DRAINAGE MEMO

BLACK FOREST MEADOWS

County Fil No.: VA211

September 15, 2021

Black Forest Meadows Outdoor Wedding Venue Concept Plan April 7, 2021

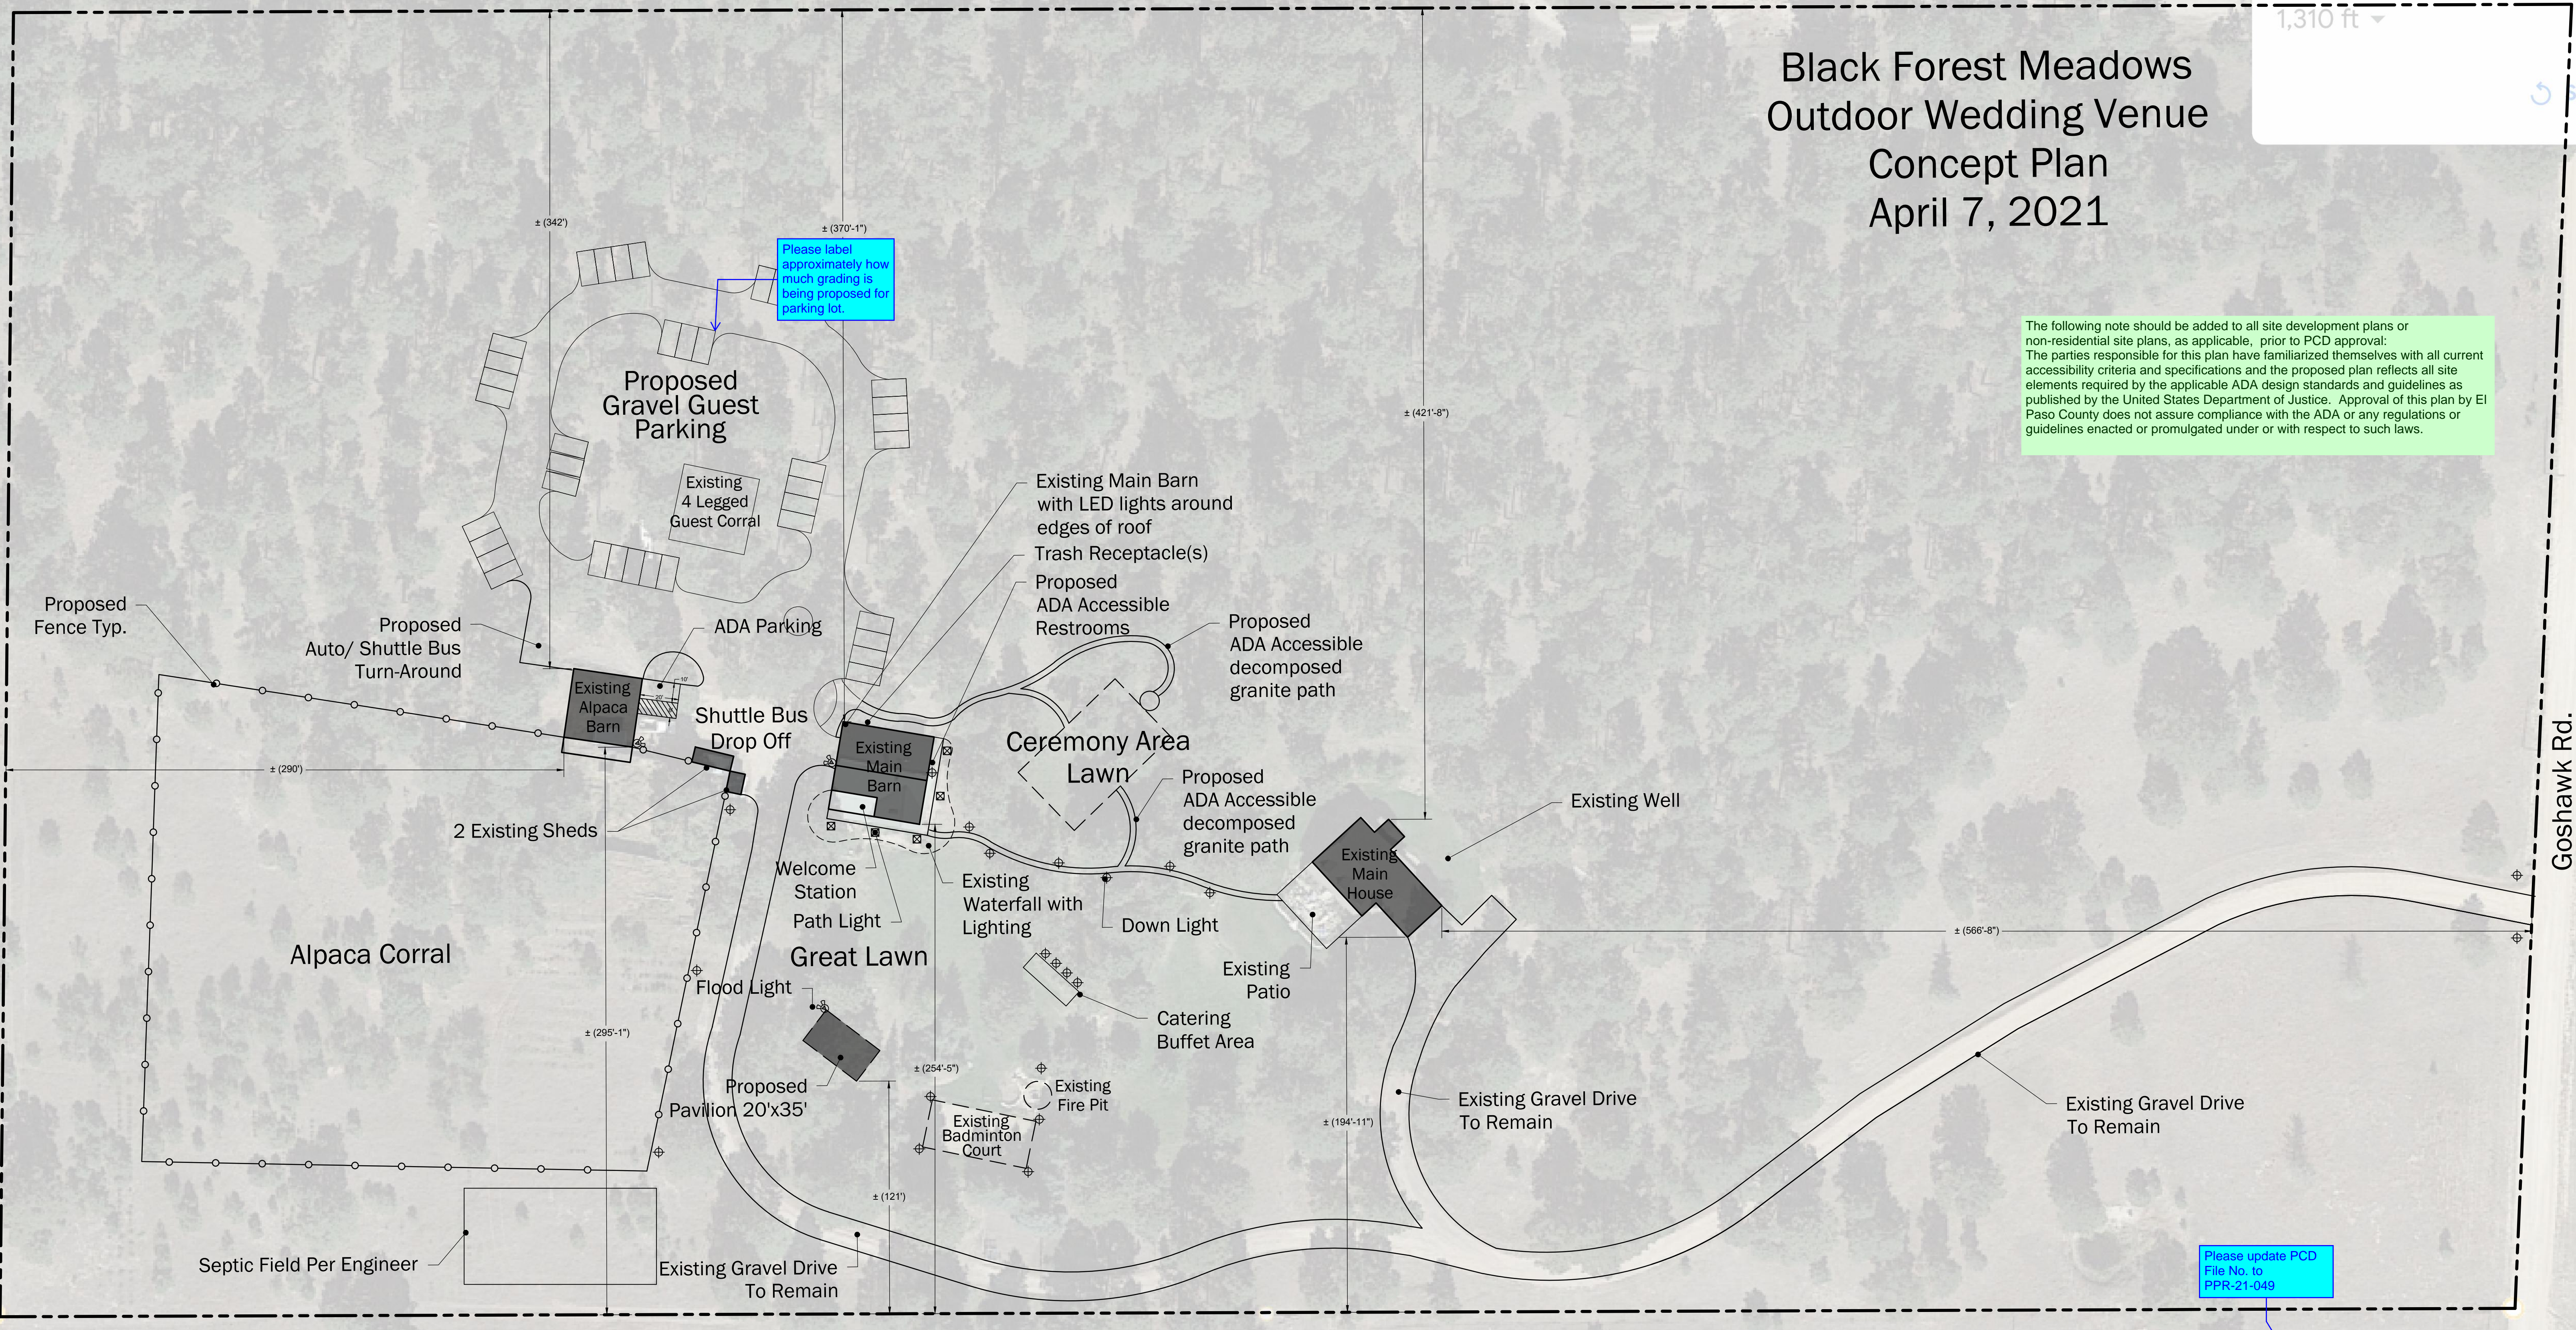
Unresolved. Please reiterate how much grading is being proposed with the inclusion of the parking lot.
